Berry, Huff, McDonald, Milligan Inc.
Engineers, Surveyors

December 19, 2014

RE: Level I-Minor Residential Development Review Site Plan Revisions
Duplex Lot
21 Mayfield Street – Greg McCormack
Tax Map 293, Block C, Lot 11
Project ID: 2104-02688

DUPLEX SITE PLAN
21 MAYFIELD STREET

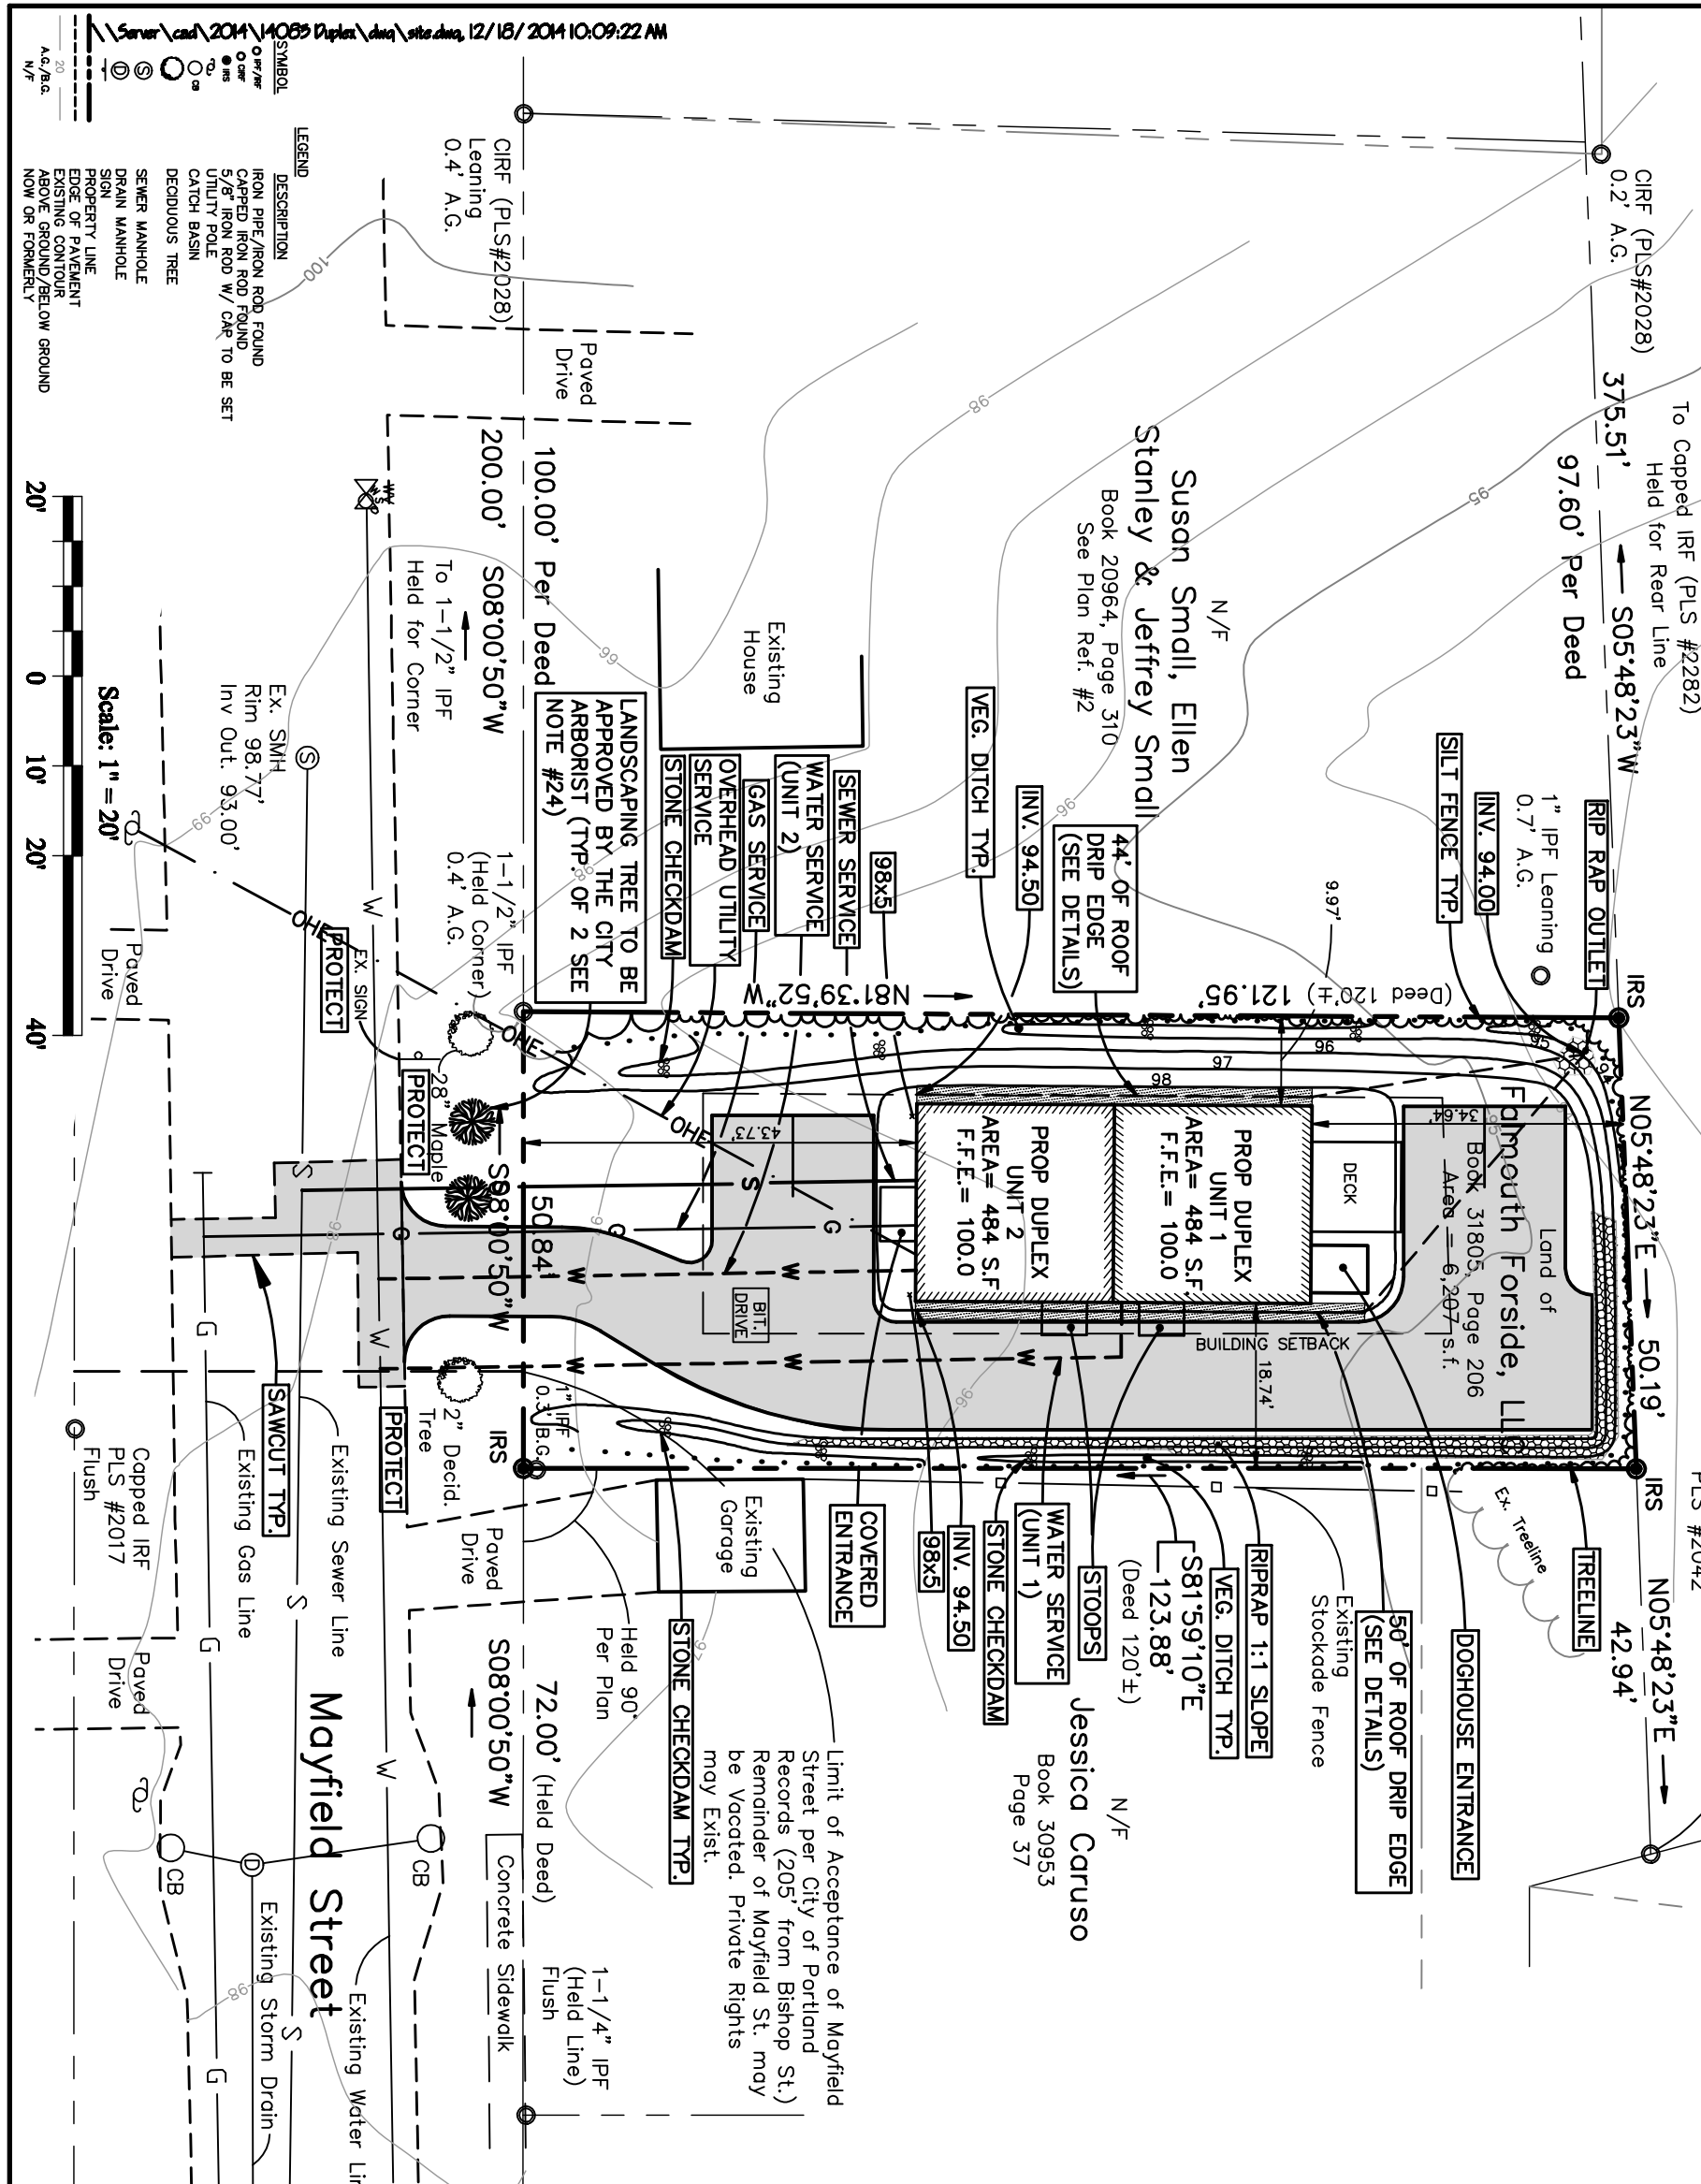
- The property owner information and supporting deed references have been revised to match the current property owners.
- Please find attached the most current deed (Deed Book 31805 Page 206).
- Plan Note #22 was added the Site Plan (Sheet 1) stating that this project is not within the 100-year flood zone per FEMA Maps.
- Property corner monumentation is shown on the Site Plan (Sheet 1). Once the project is approved and constructed BH2M will set capped iron rods at three of the property corners (one corner currently has survey monumentation).

- All conveyances and easements have been shown on the plans as requested.
- Plan Note #23 has been added to the Site Plan (Sheet 1) as requested regarding the street status of Mayfield Street. Please note the information also added in the plan view.

- The building offset dimensions from each property line has been added to the plans (see Site plan-Sheet 1).
- A small vegetated ditch has been added to both the North and South sides of the proposed duplex to assure that runoff from the developed portions of the site flow to the rear of the parcel (West), where the runoff currently flows under pre development conditions, and assures no adverse impacts are created to the abutting homes of Stanley/Small to the South and Caruso to the North. Please note that stone check dams have also been proposed within the ditch to limit sediment transport throughout the site. Please also note that all pertinent details have also been added to the Detail Sheet (Sheet 2).

- All pertinent erosion control measures have been labeled on the plan (see Site Plan-Sheet 1).
- The required two proposed street trees have been added to the plans as required along Mayfield Street.

- The proposed driveway has been revised to meet the offset requirements (from the driveway of Caruso to the north) as well as the minimum width requirements outlined within the City Ordinance.

- The proposed overhead utility service has been relocated as recommended to avoid the need for an easement on the abutting property.
- The developer prefers the current parking configuration for the development of this site. By relocating the parking as recommended by the City there is a concern that the distance required for potential owners to walk from the rear parking to the front unit (Unit 2) is too far and could be a deterrent to some potential buyers. The current configuration meets the City Ordinance and the applicant would prefer to develop the site as shown on the attached plans.
